Addendum No. 1

RE: Contract ID: C202411

US-70/NC-50 (Glenwood Ave.) From Women's Club To
Pavement Joint North of Wade Avenue

August 18, 2009 Letting

PROJ. REFERENCE NO.	SHEET NO.	TOTAL SHEETS
5CR.1092 I.19	2	5
STATE PROJ. NO.	F.A. PROJ. NO.	DESCRIPTION

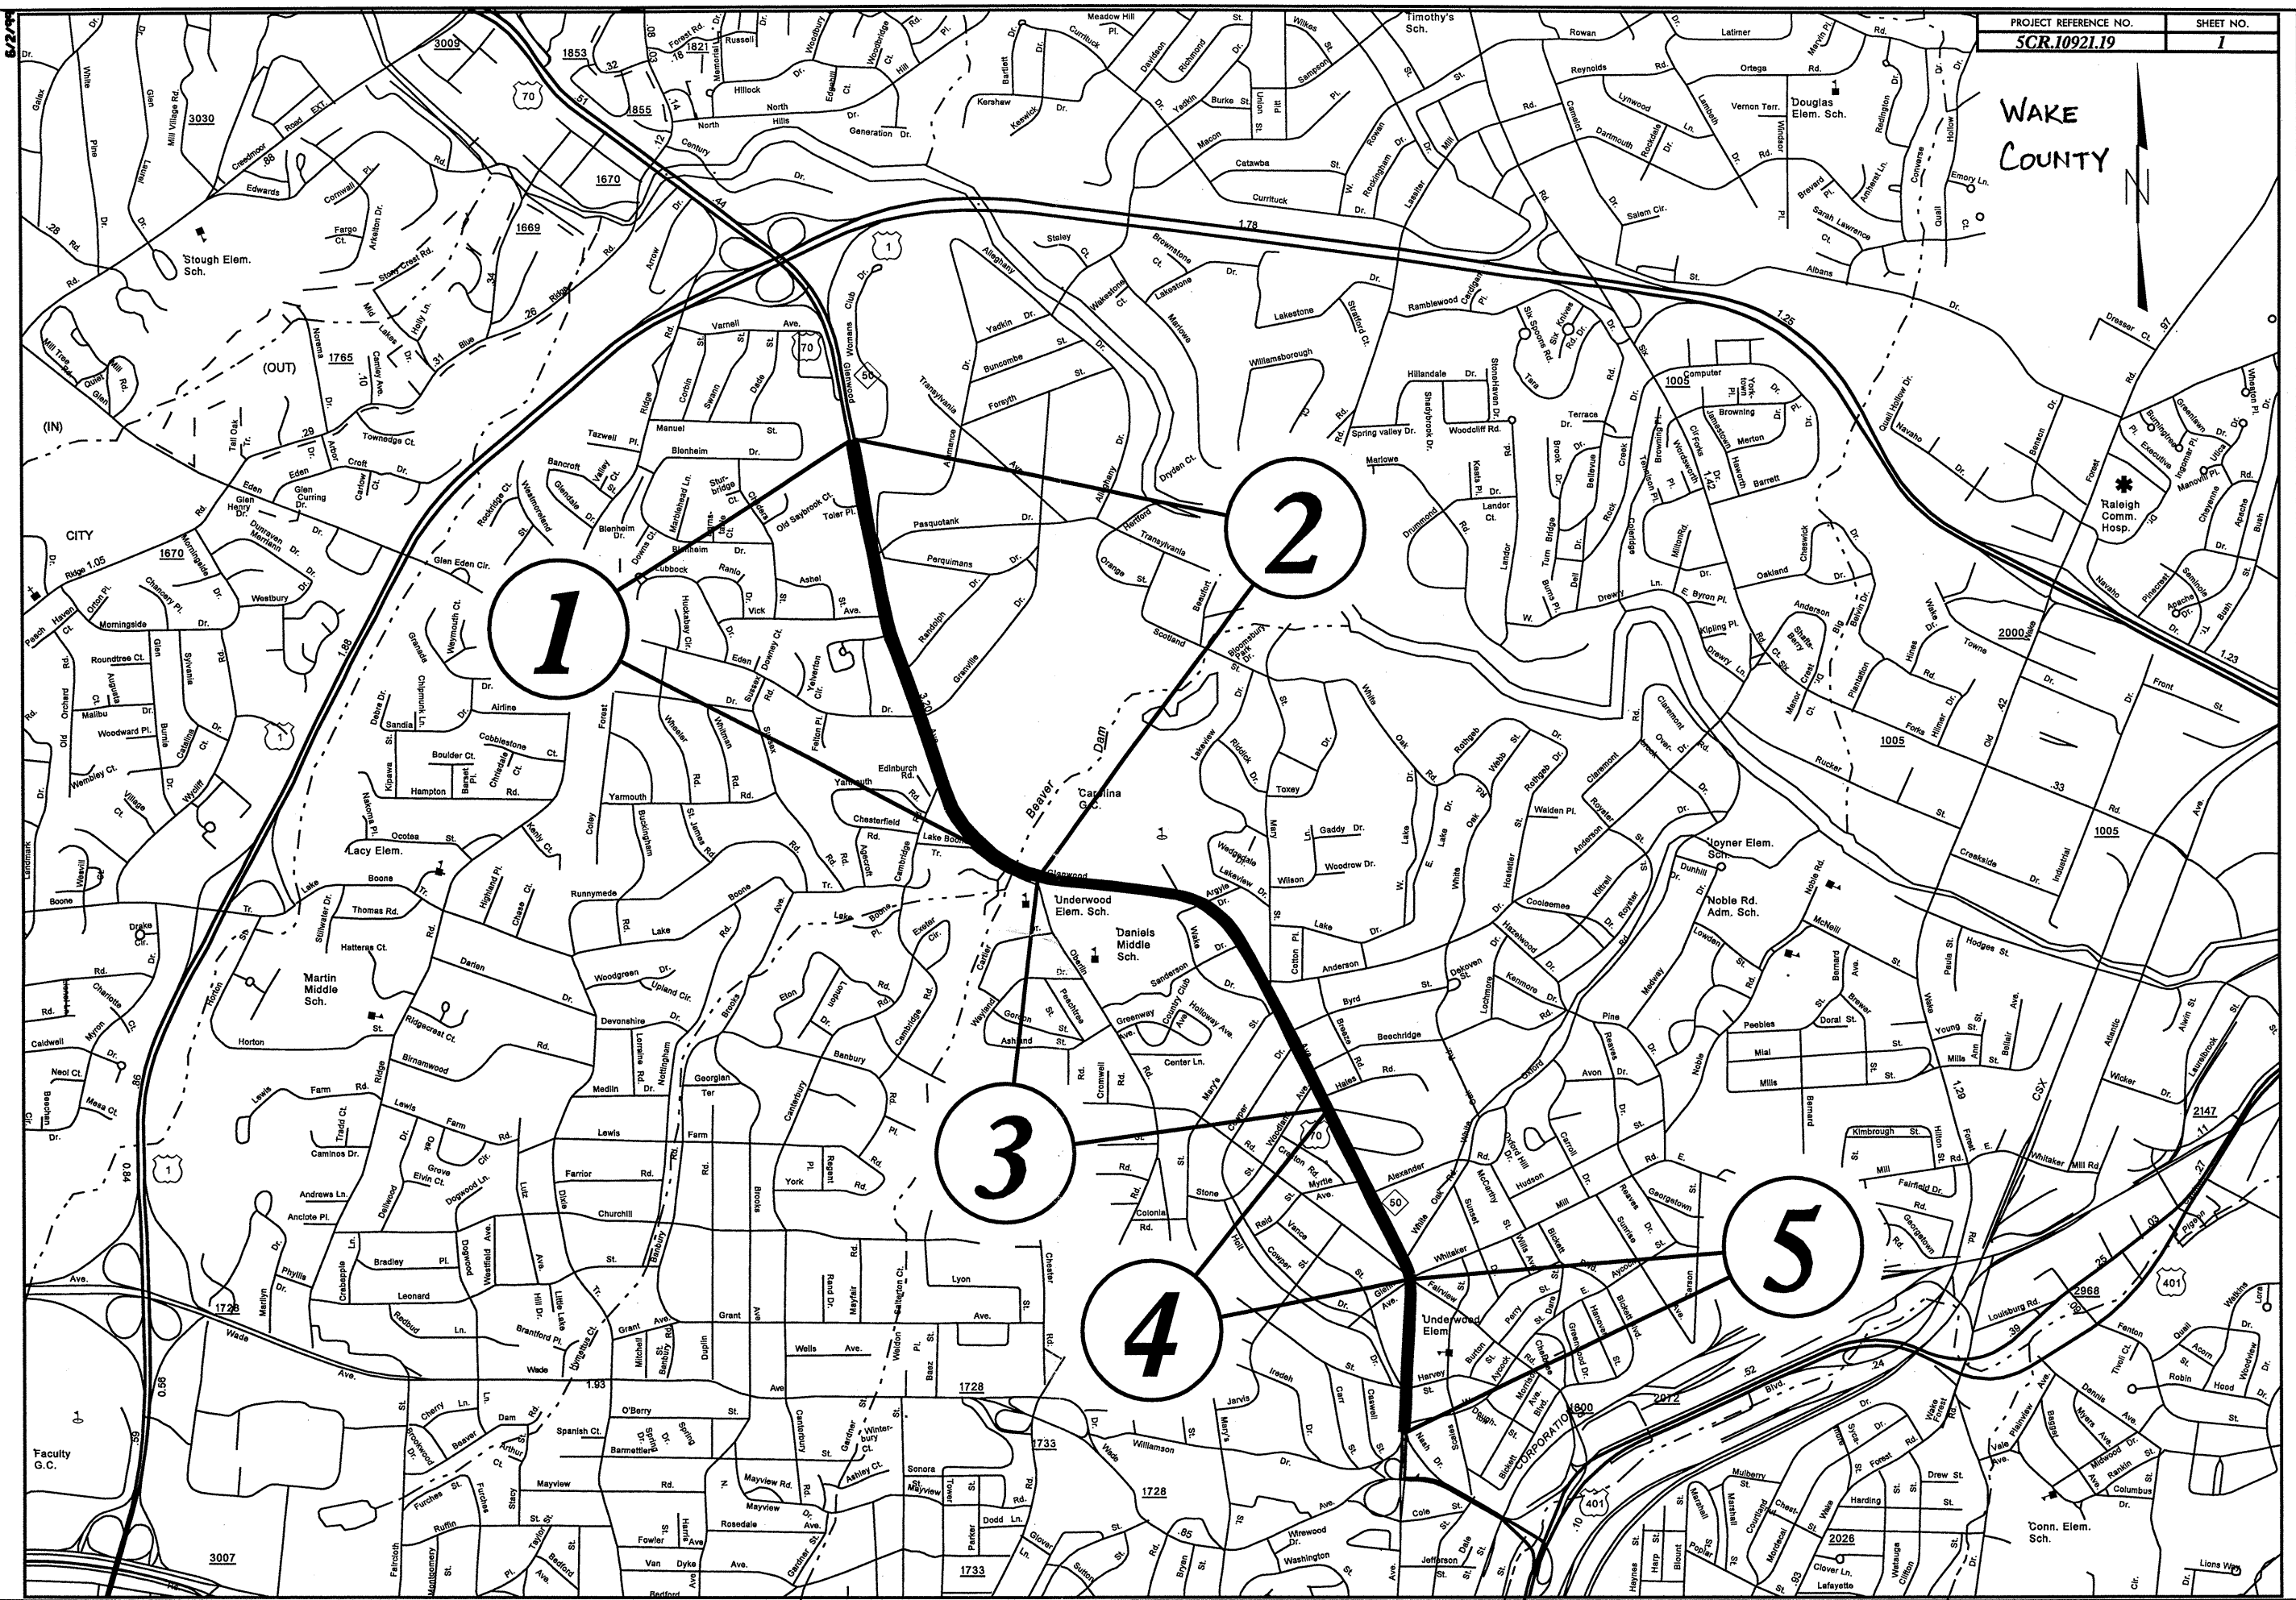
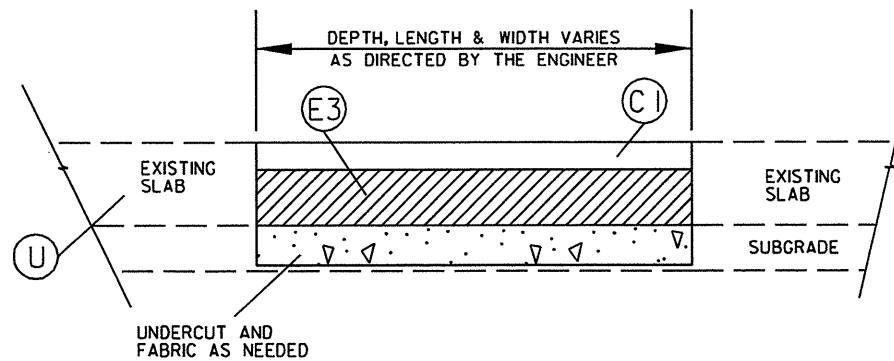
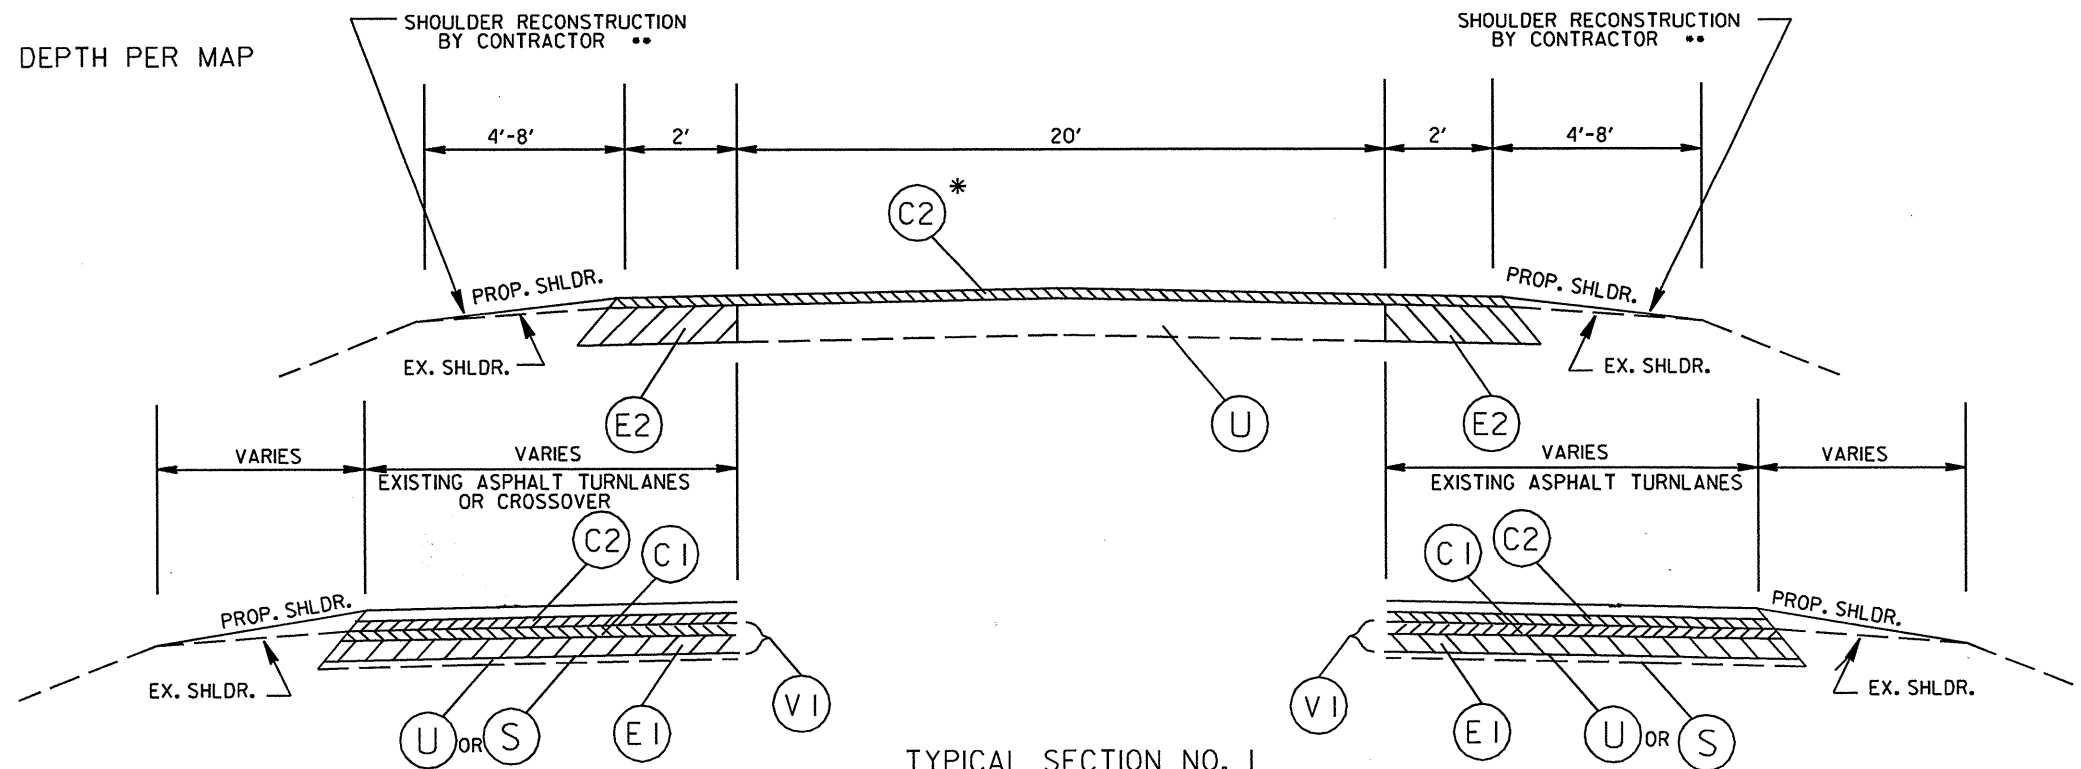
Sheet Nos. 2, 3, 4 and 5 have been revised to reflect the deletion of the Ultra-Thin Hot Mix.
